# CITY OF ALBUQUERQUE

## OFFICIAL NOTIFICATION OF DECISION

**Project # 1009204**  
12EPC-40015 Site Development Plan for  
Building Permit  
12EPC-40018 Amendment to Zone Map (Zone  
Change)

For the northerly portion of Lot 33, Alvarado Gardens, Unit 1, located on Rio Grande Boulevard NW between Contreras Place & Matthew Avenue containing approximately 1.2 acres.  
Randall Falkner, Staff Planner

B1 LANDSCAPE PLAN
SCALE: 1" = 20'

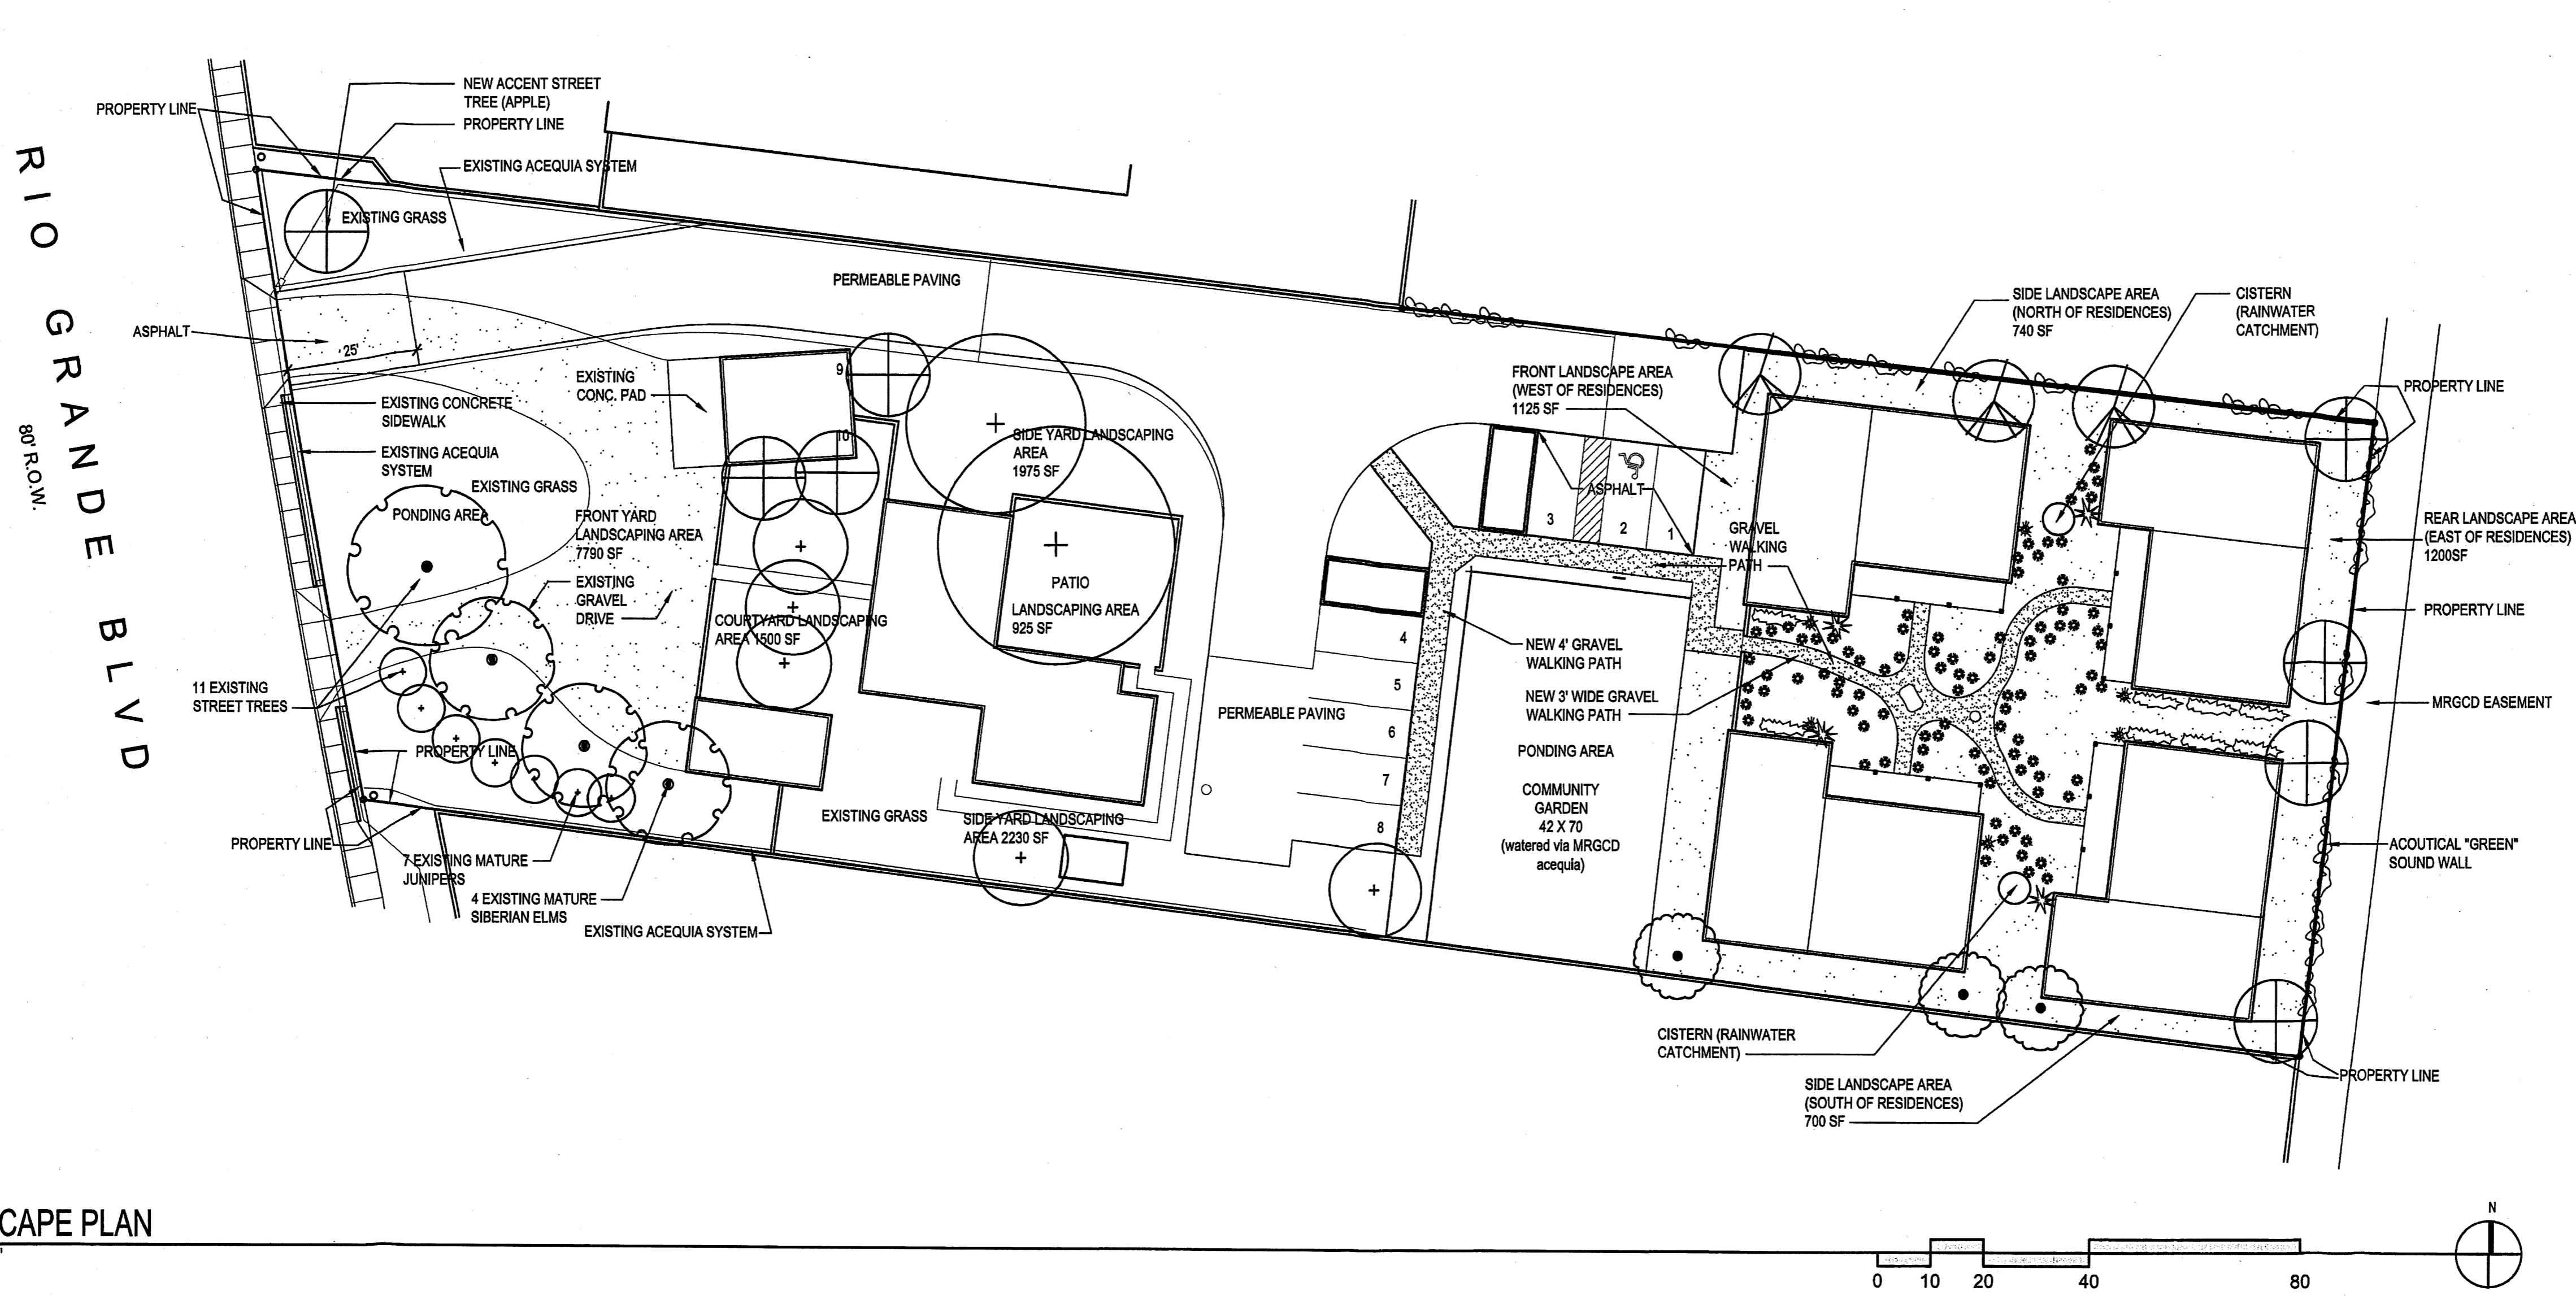
10. The existing chain link fence shall be replaced with a solid wall that incorporates green principles.
11. The landscaping shown on the landscape plan shall match the landscaping shown on the landscaping legend.

CONCEPTUAL GRADING AND DRAINAGE PLAN

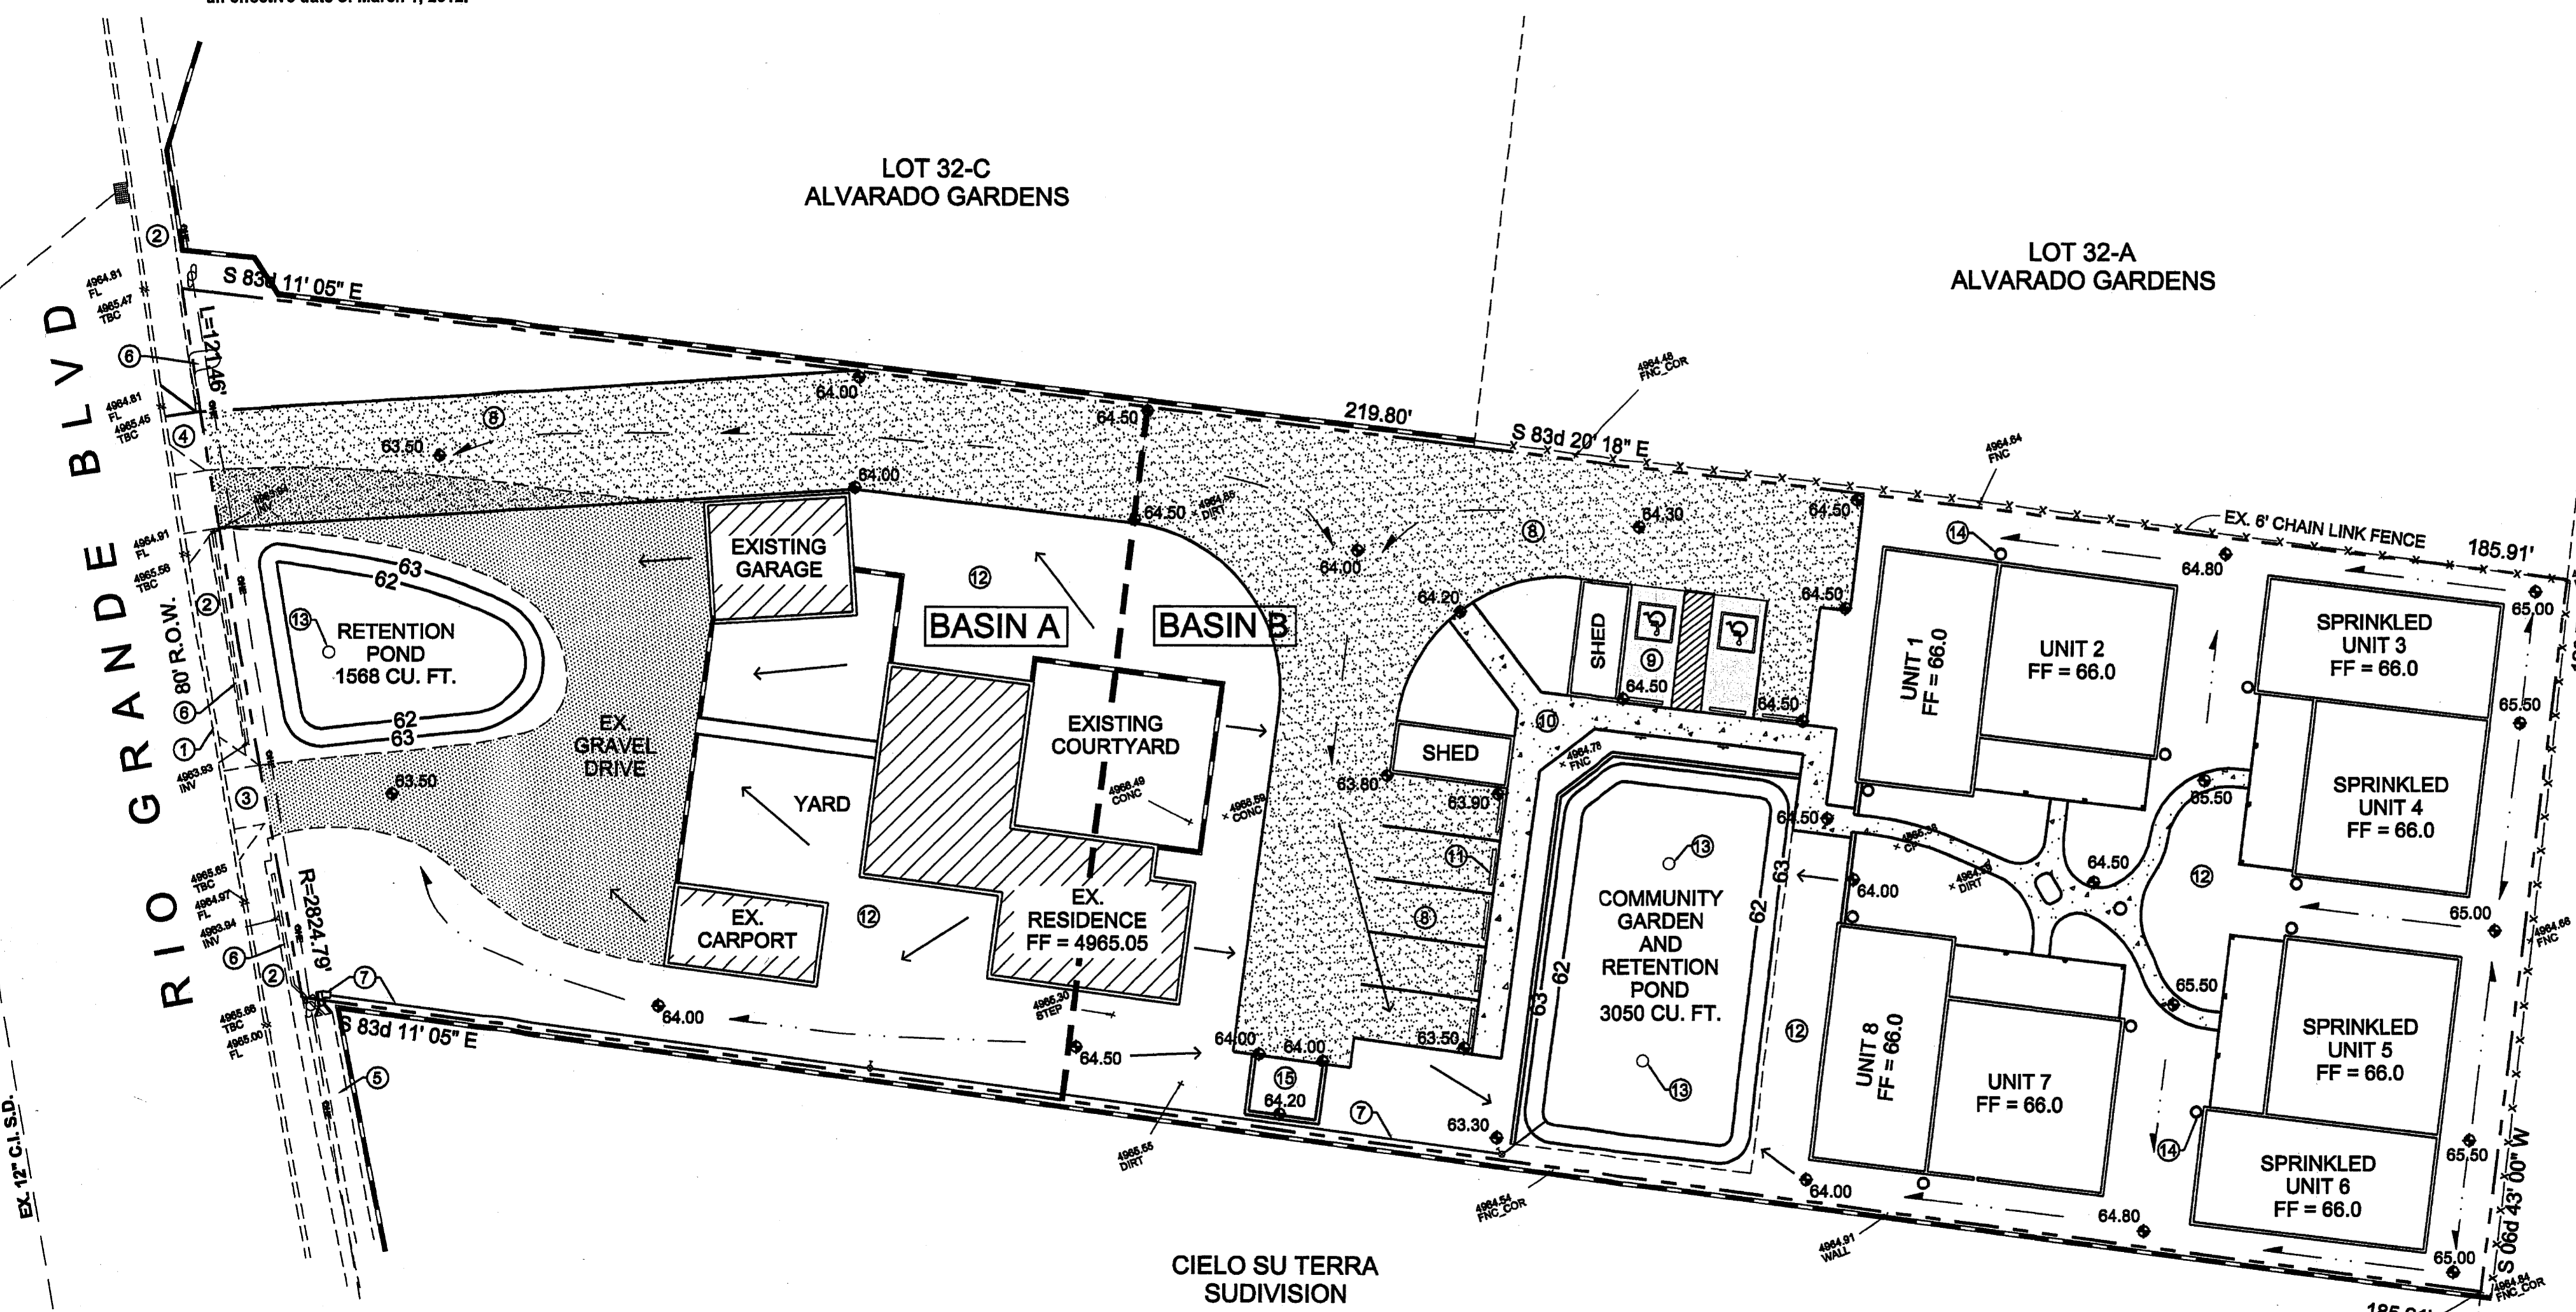
- f. All easements need to be shown and labeled on Site Plan.
  - g. Site plan shall comply and be designed per DPM Standards
  - h. Change the beginning of paragraph 9.0 to "The City of Albuquerque has received its EPA MS4 Permit for stormwater quality with an effective date of March 1, 2012."

CONCEPTUAL UTILITY PLAN

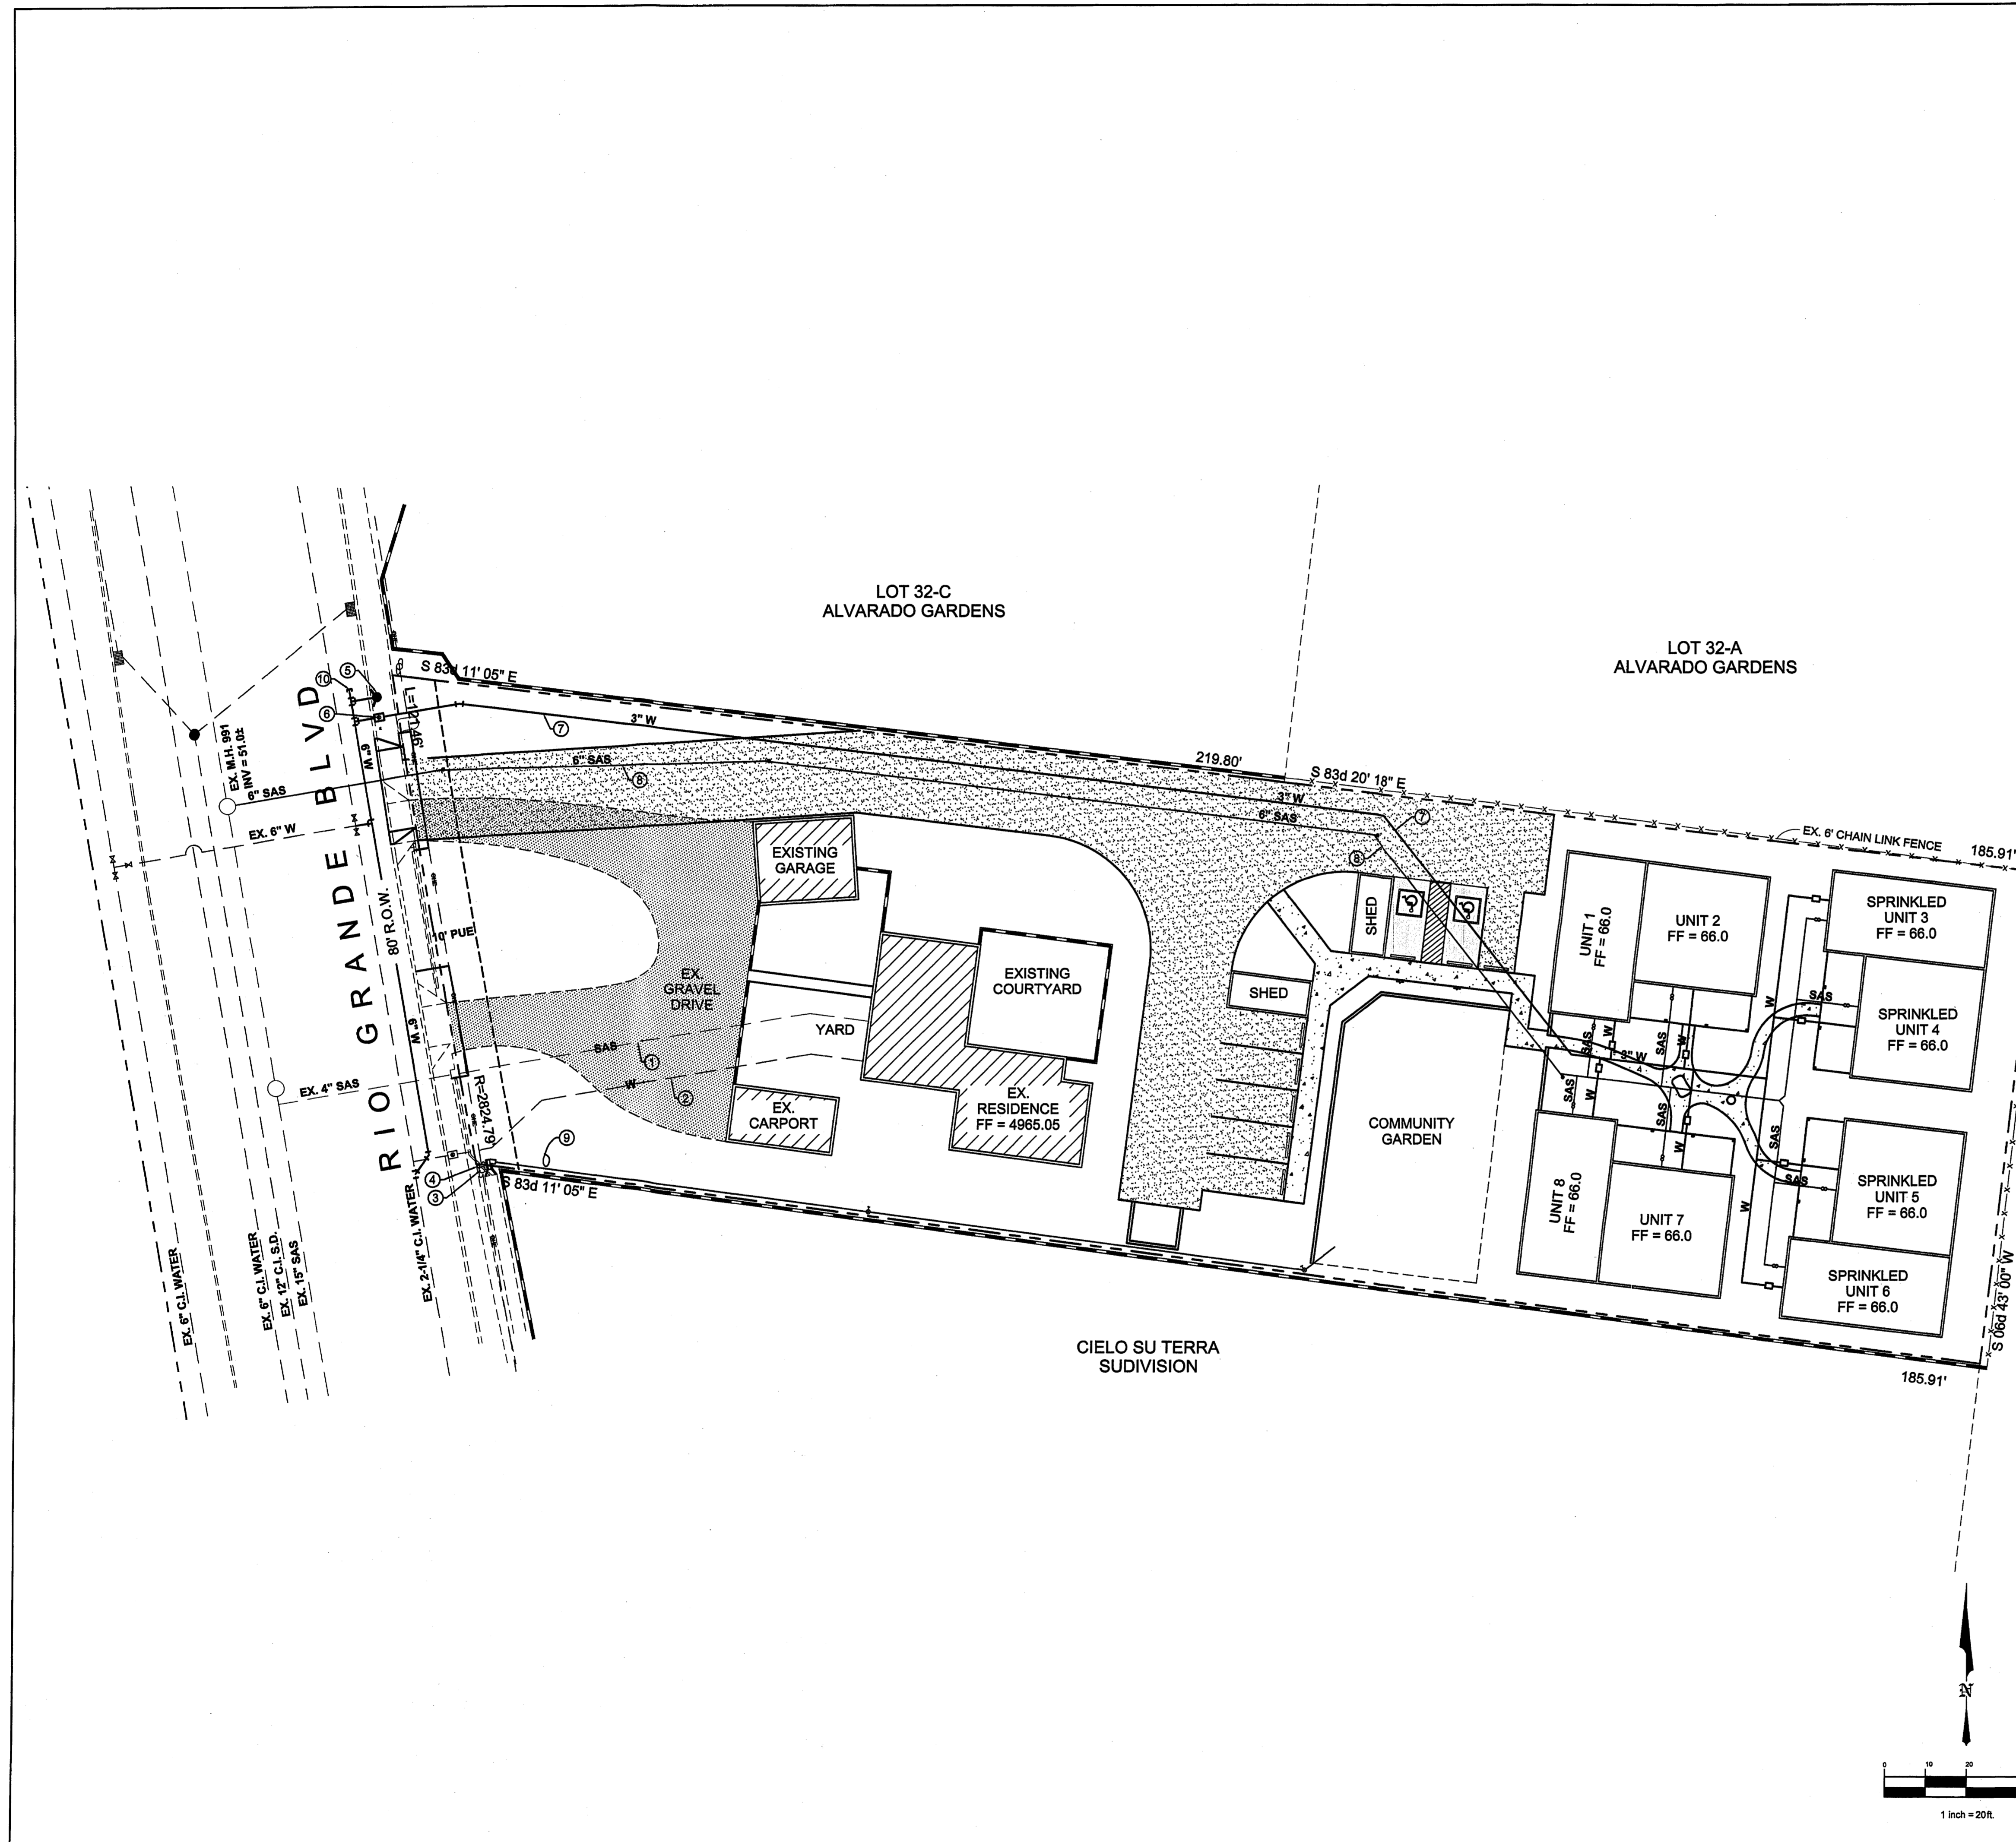
- b. Screening should be designed to allow for access to utility facilities. As a condition, all screening and vegetation surrounding ground-mounted transformers and utility pads are to allow 10 feet of clearance in front of the equipment door and 5-6 feet of clearance on the remaining three sides for safe operation, maintenance and repair purposes. Please refer to the PNM Electric Service Guide for specifications.

- c. As a condition, it is recommended that the developer contact PNM's New Service Delivery Department to coordinate electric service regarding this project. Any existing or proposed public utility easements are to be indicated on the site plan utility sheet prior to DRB review. PNM's standard for public utility easements for distribution is 10 feet in width to ensure adequate, safe clearances.
